**1st REVIEW – DEVELOPMENT PLAN – APPROVED WITH CORRECTIONS
CIMARRON HILLS FIRE PROTECTION DISTRICT (CH2017-35-DP-1)**

August 2, 2017

FILE NUMBER: PPR-17-031

The Cimarron Hills Fire Department submitted an electronic development plan to PEAK Consulting Services, Inc. for a fire code compliance review of a proposed commercial building for the **NEW CRACKERJACK MUD JACKING BUILDING** located at **1411 Woolsey Heights** within the Cimarron Hills Fire Protection District. This scope of work includes: **A new 3,750 square foot single story industrial building.**

JOB NUMBER	696-17
REVISIONS	
8-26-17	PER COUNTY COMMENTS
ORIGINAL DATE	6-28-17
DRAWN BY:	JM
DESCRIPTION:	LANDSCAPE PLAN
SHEET NO.	LP-01
	PPR-17-031

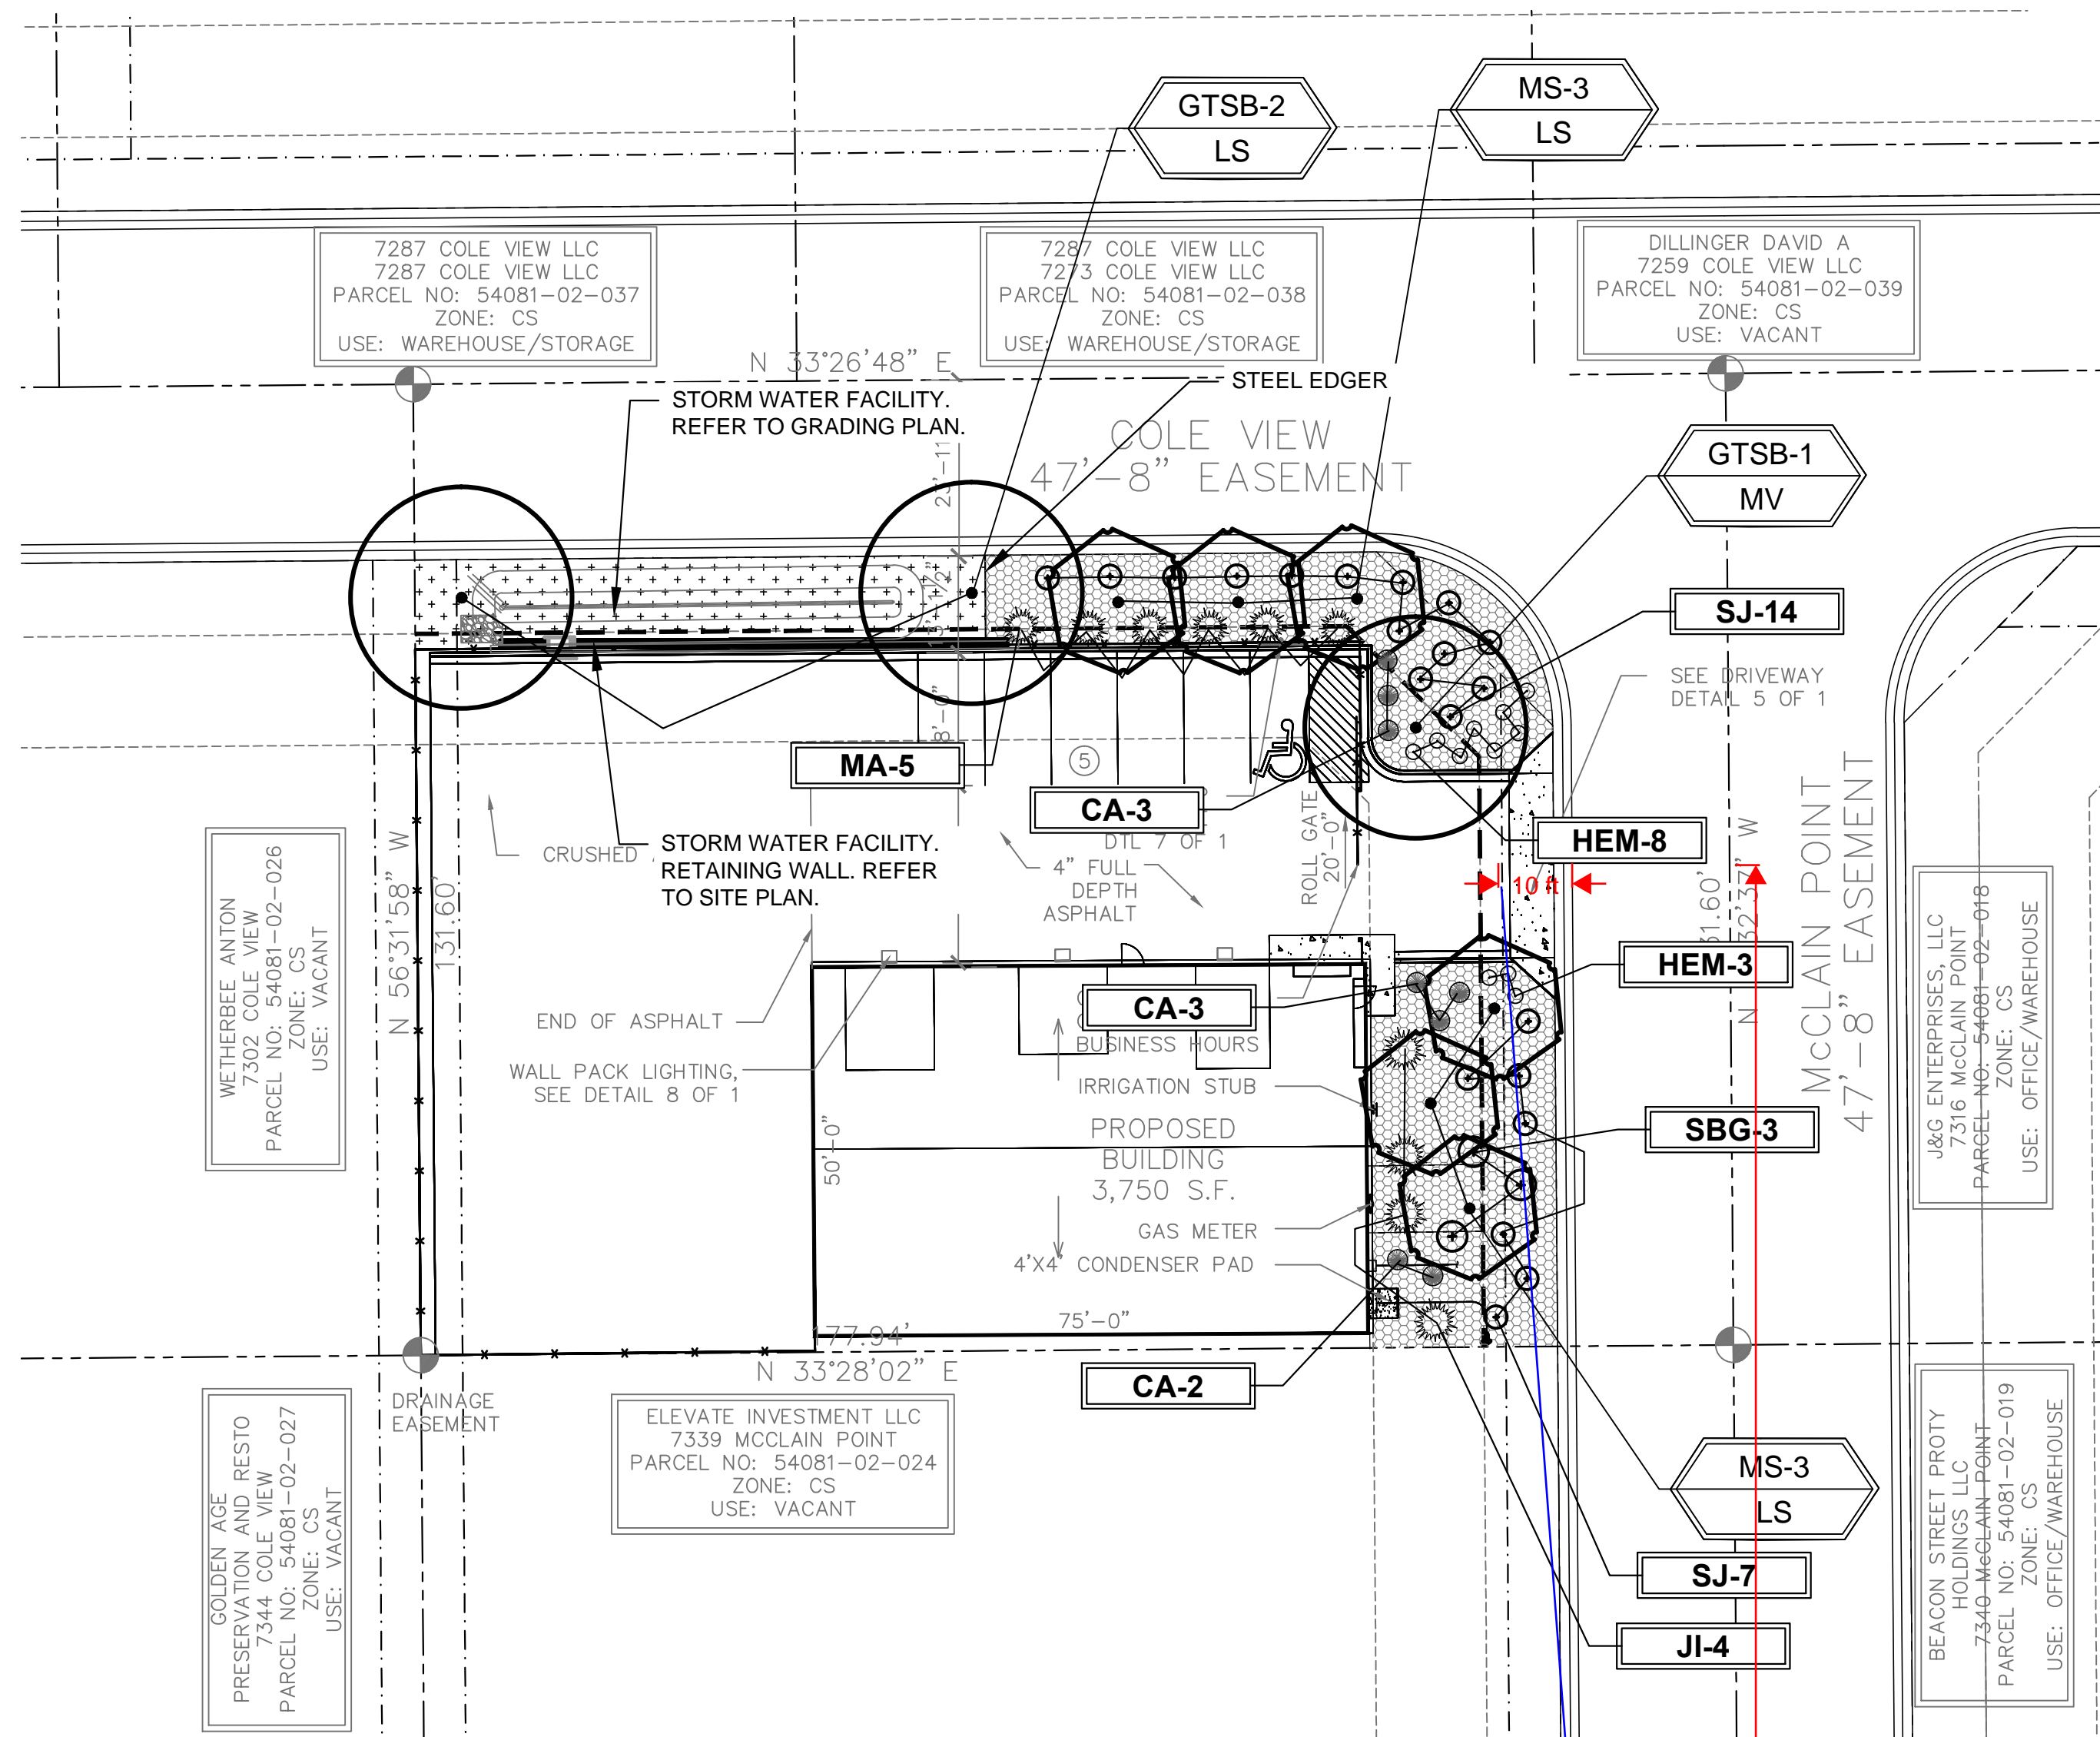
TURNING RADIUS – The East End of this development indicates that there will be RV parking. NOTE: Turning Radius requirements shall be maintained and not impeded upon parked RV's.
